The Aldwick Bay Estate

**Re: Planning Application AW/335/14/HH
4 Tithe Barn Way, Aldwick Bay
Alterations and garage extension and new garden wall**

Site Plan 1 : 200

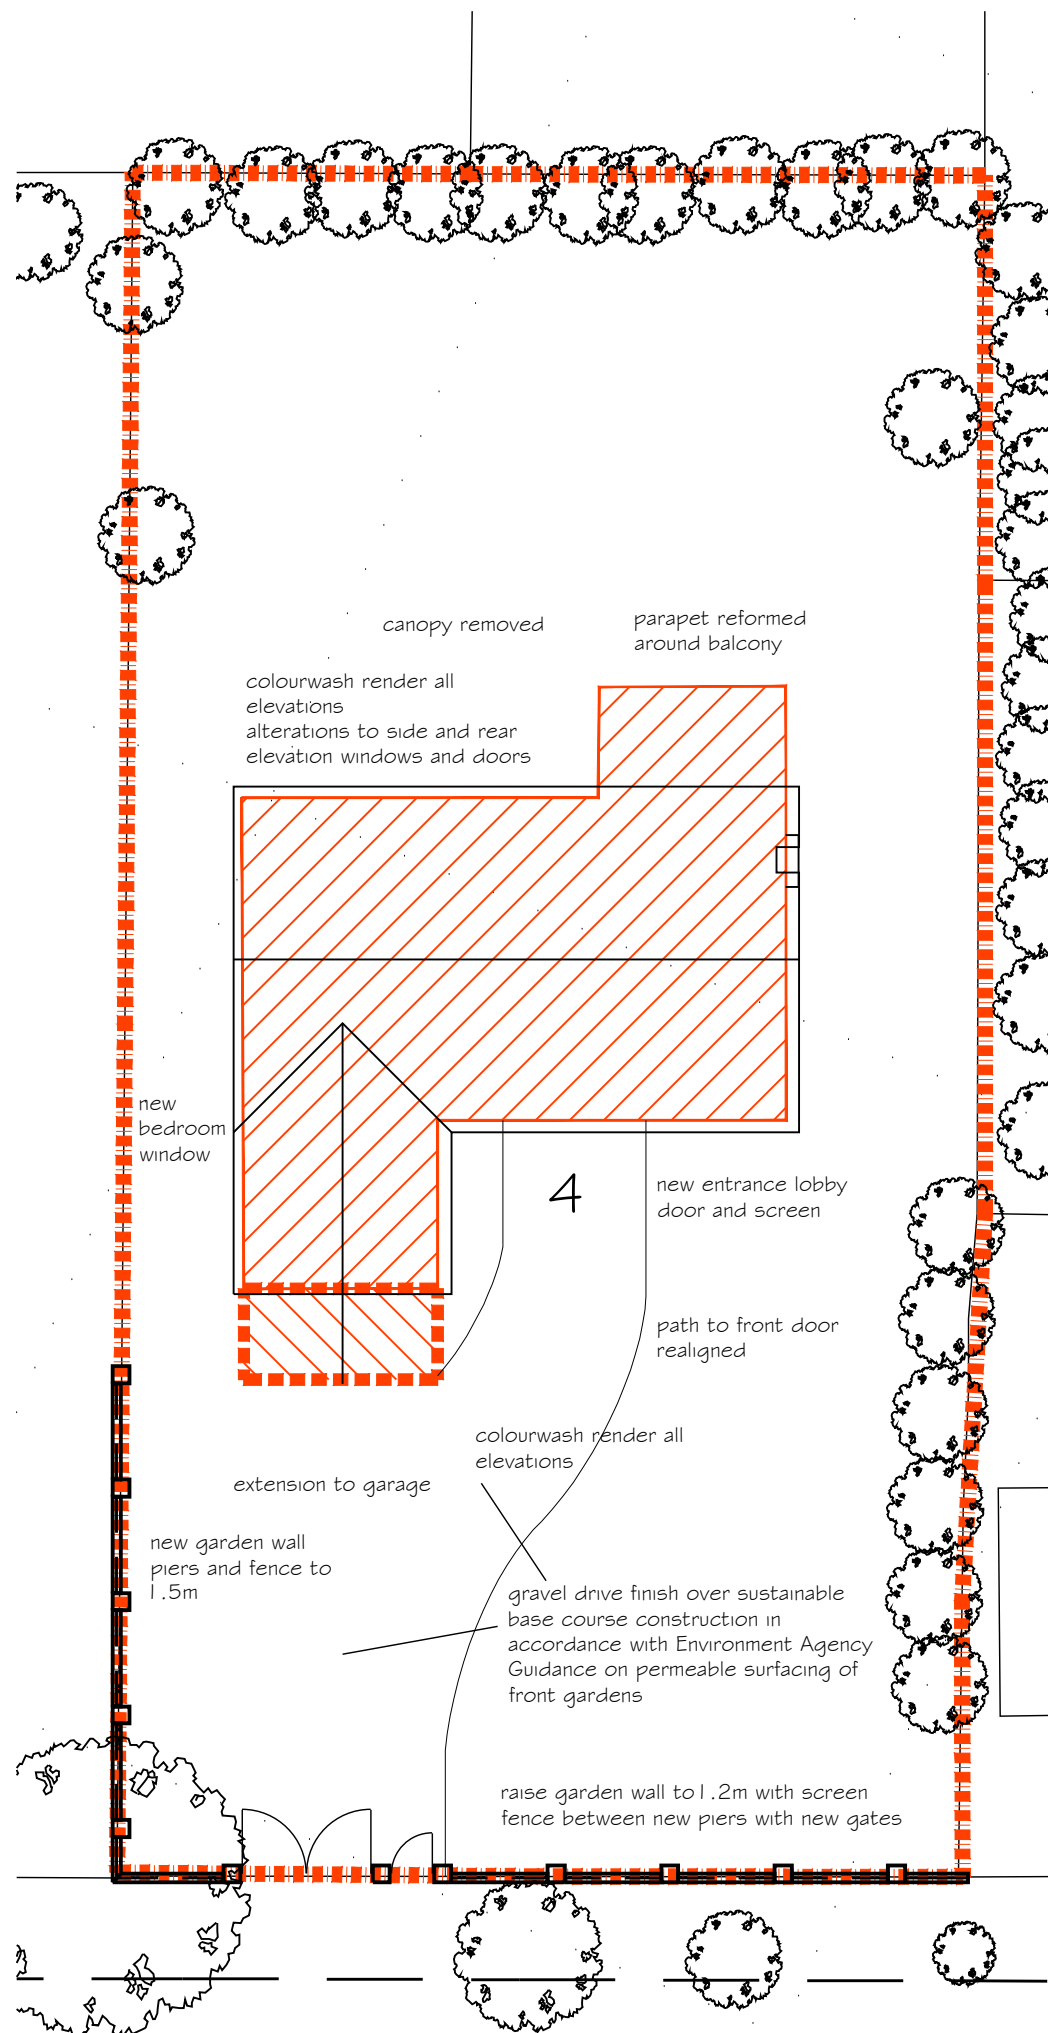
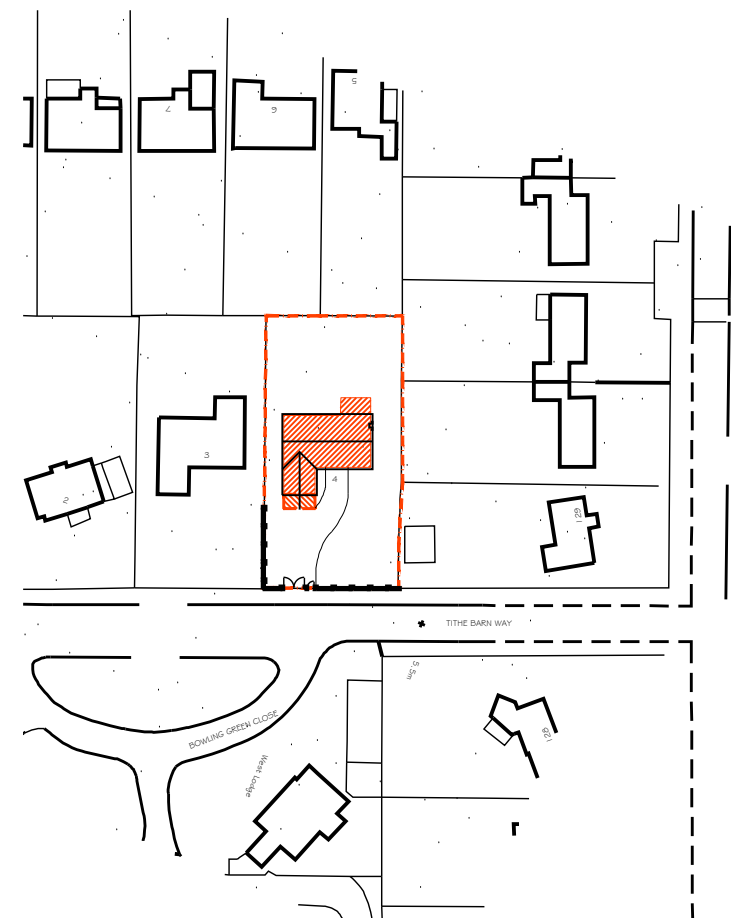
Furthermore the pine trees in the grass verge are not accurately located on the site plan and particularly the tree in the south/east corner is much larger than indicated on the drawing. The proposed fence will have a harmful effect on these TPOs. The Board **objects** to that.

Title
Ground Floor
Plans as Proposed

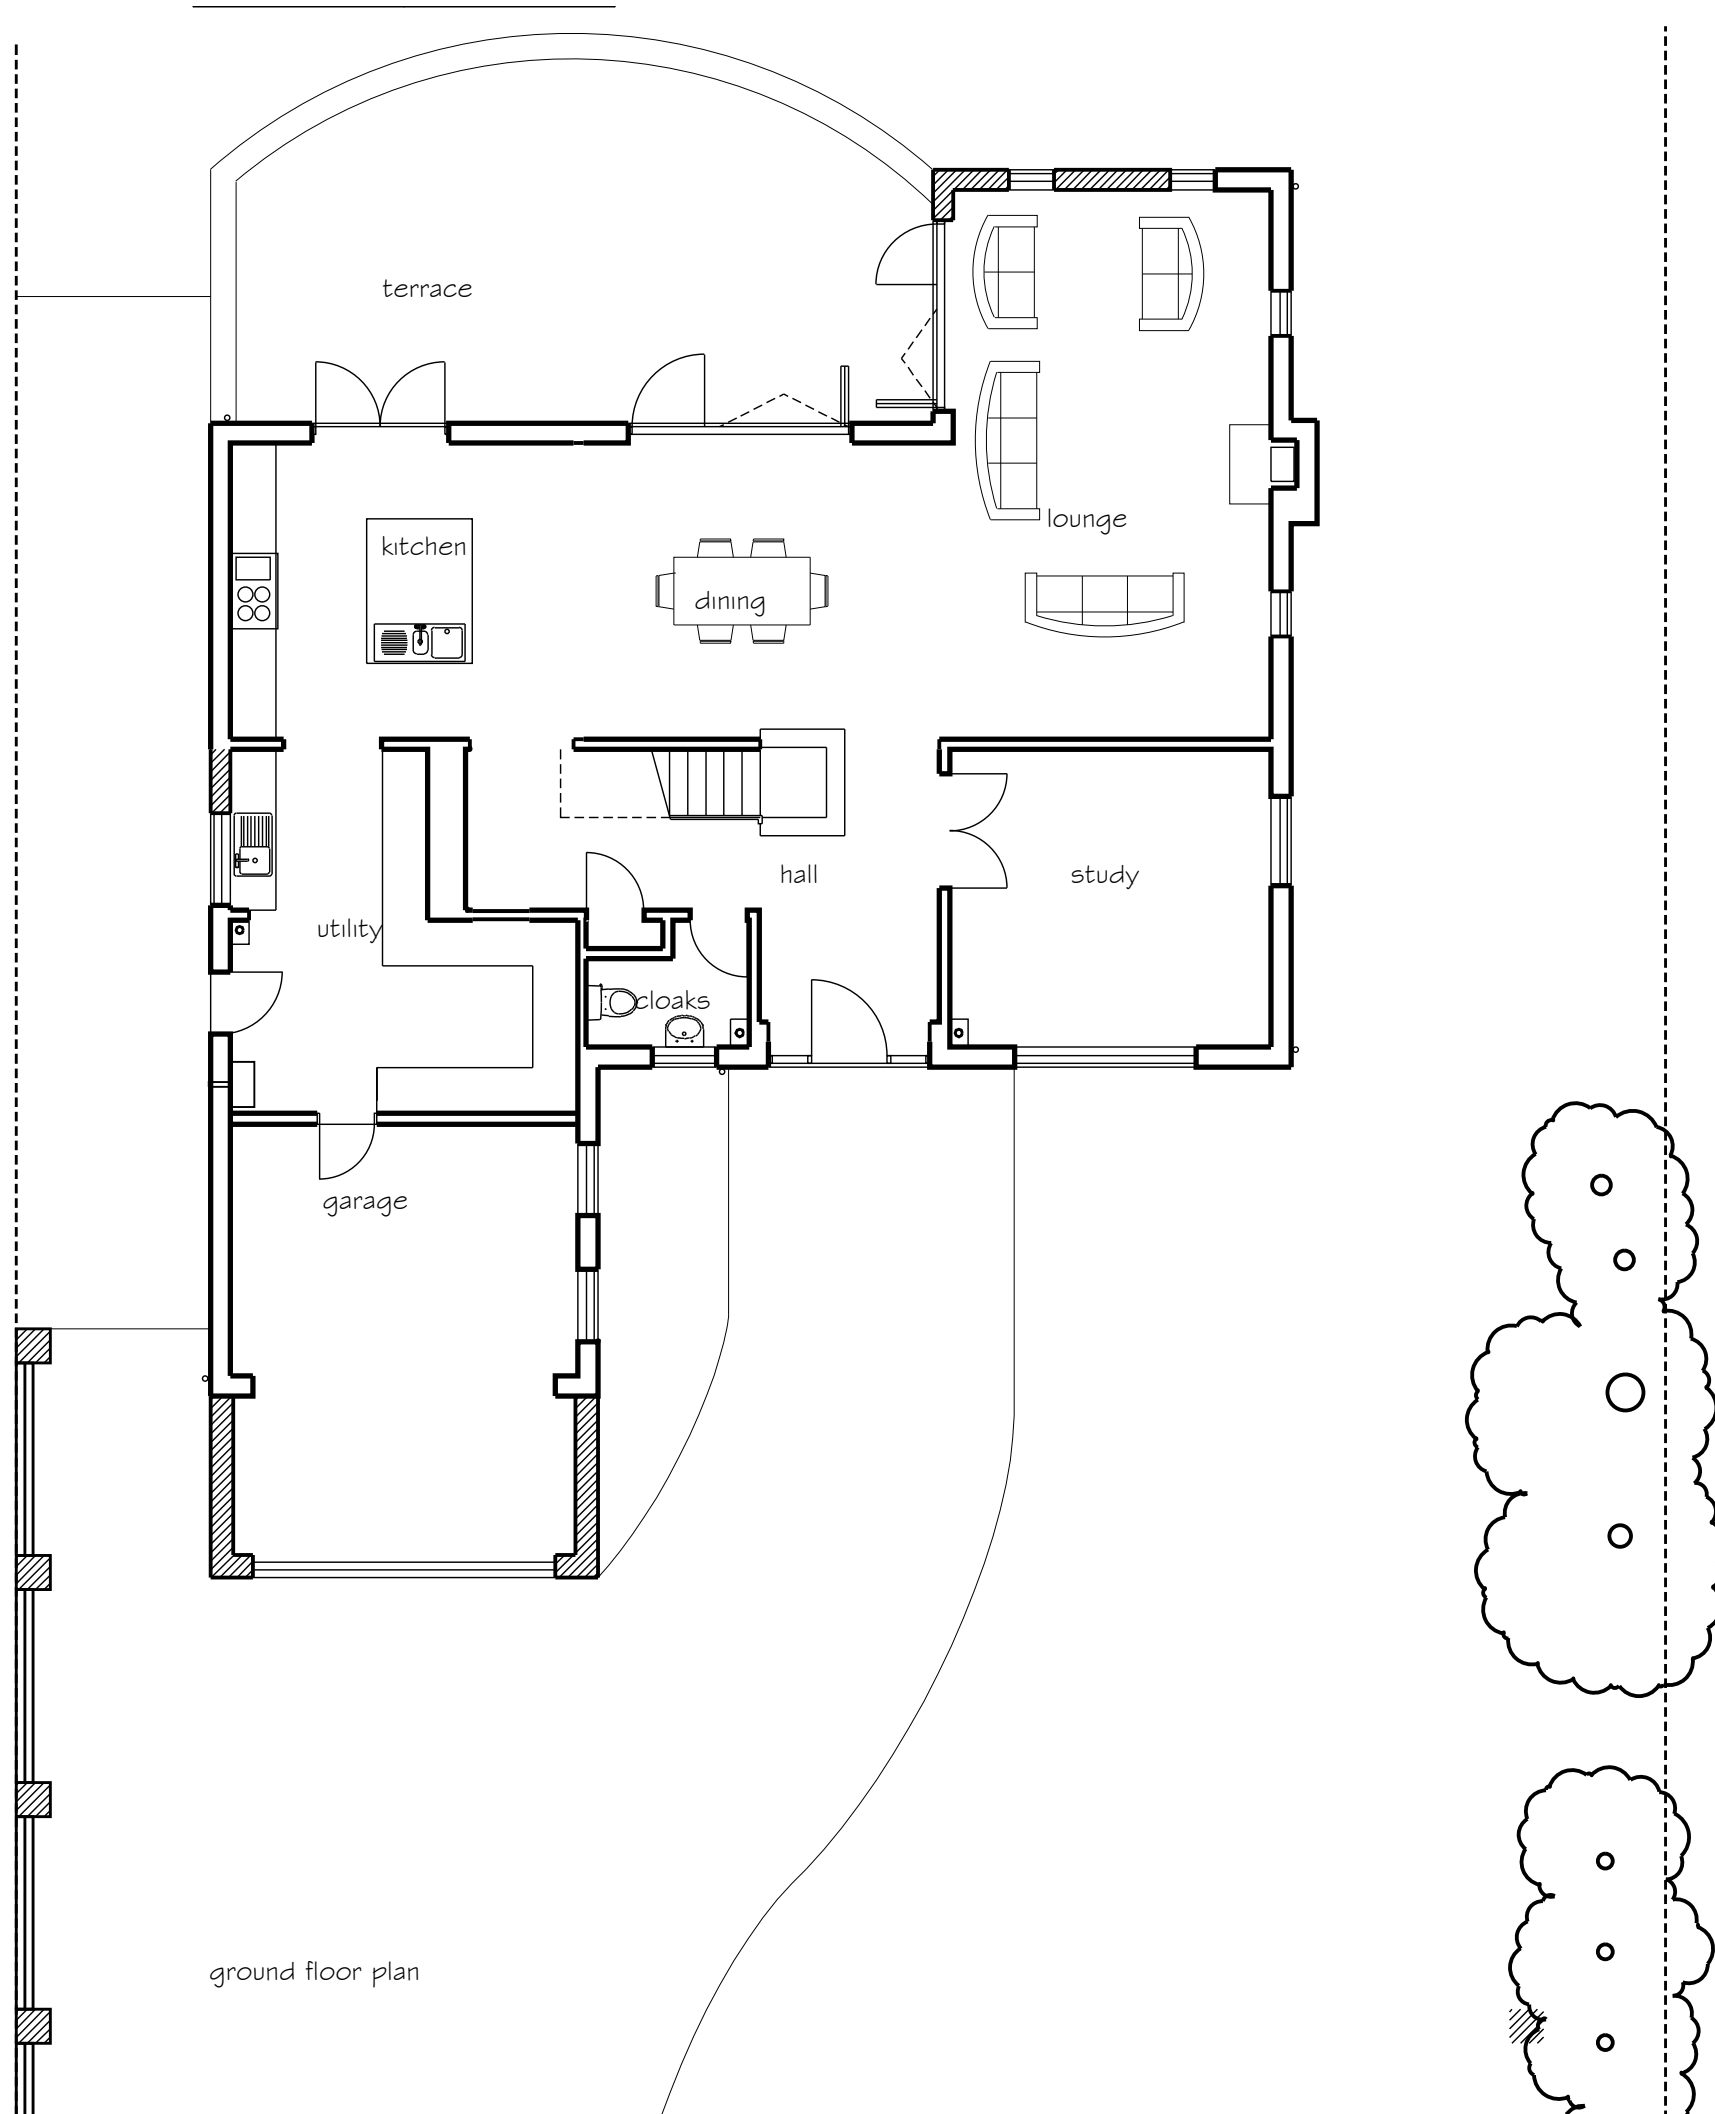
Tithe Barn Way has all open front gardens design, with low front brick walls in fairfaced stock bricks separating the gardens from the road's grass verge. The 'pier and panel' fence at a height of 1.2m proposed is out of keeping with this and would have a detrimental effect to the character of this road. The Board **objects** to that.

Title
West and North
Elevations as Proposed

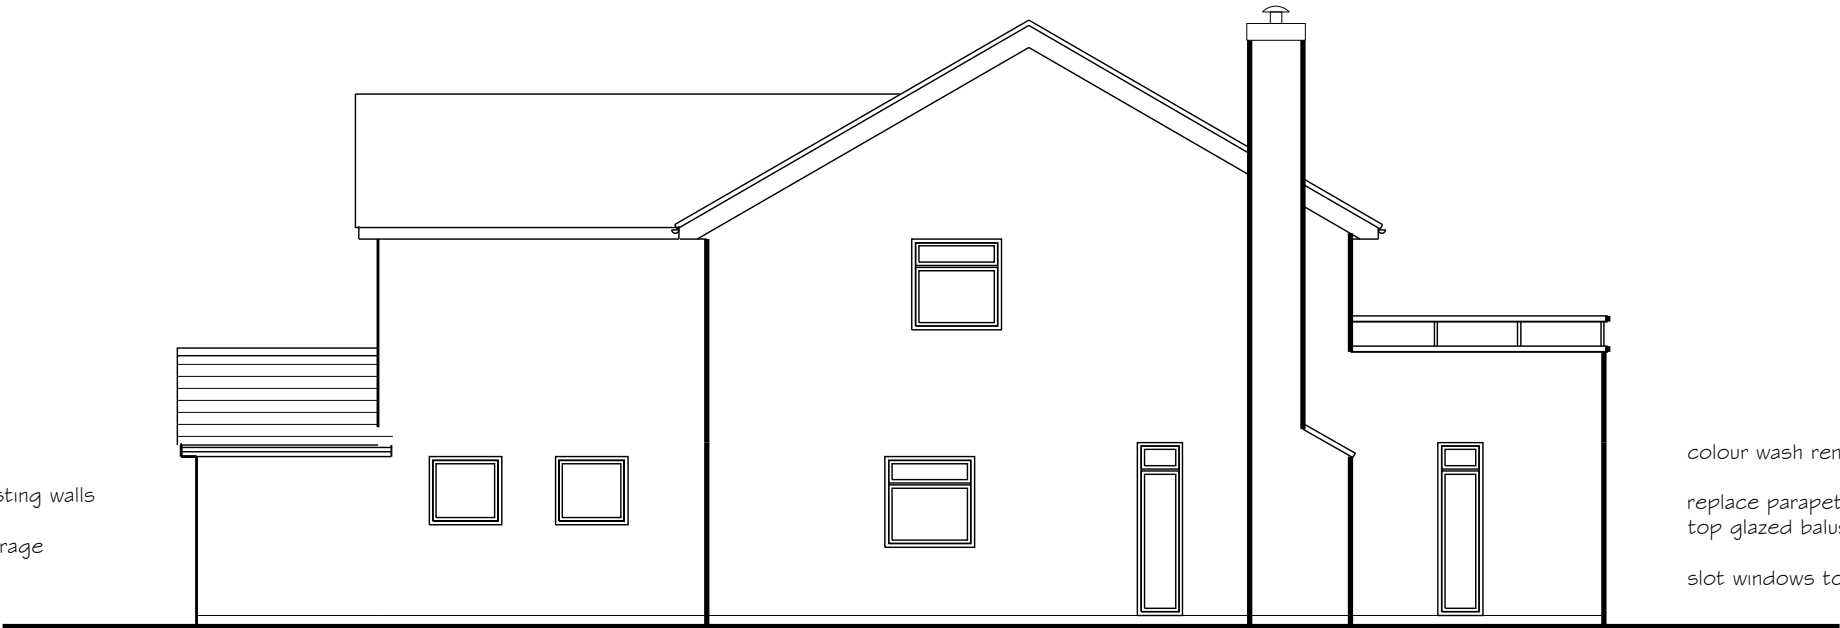
With reference to the alterations proposed to the elevations, the Board welcomes removal of UPVC boarding and we would not be against alterations to some of the fairfaced brick elevations. The proposal to a uniform 'colour wash render' to all of the ground floor, first floor and gable elevations in a light grey colour would not be appropriate in this location and be out of Tithe Barn Road character. The Board **objects** to that.
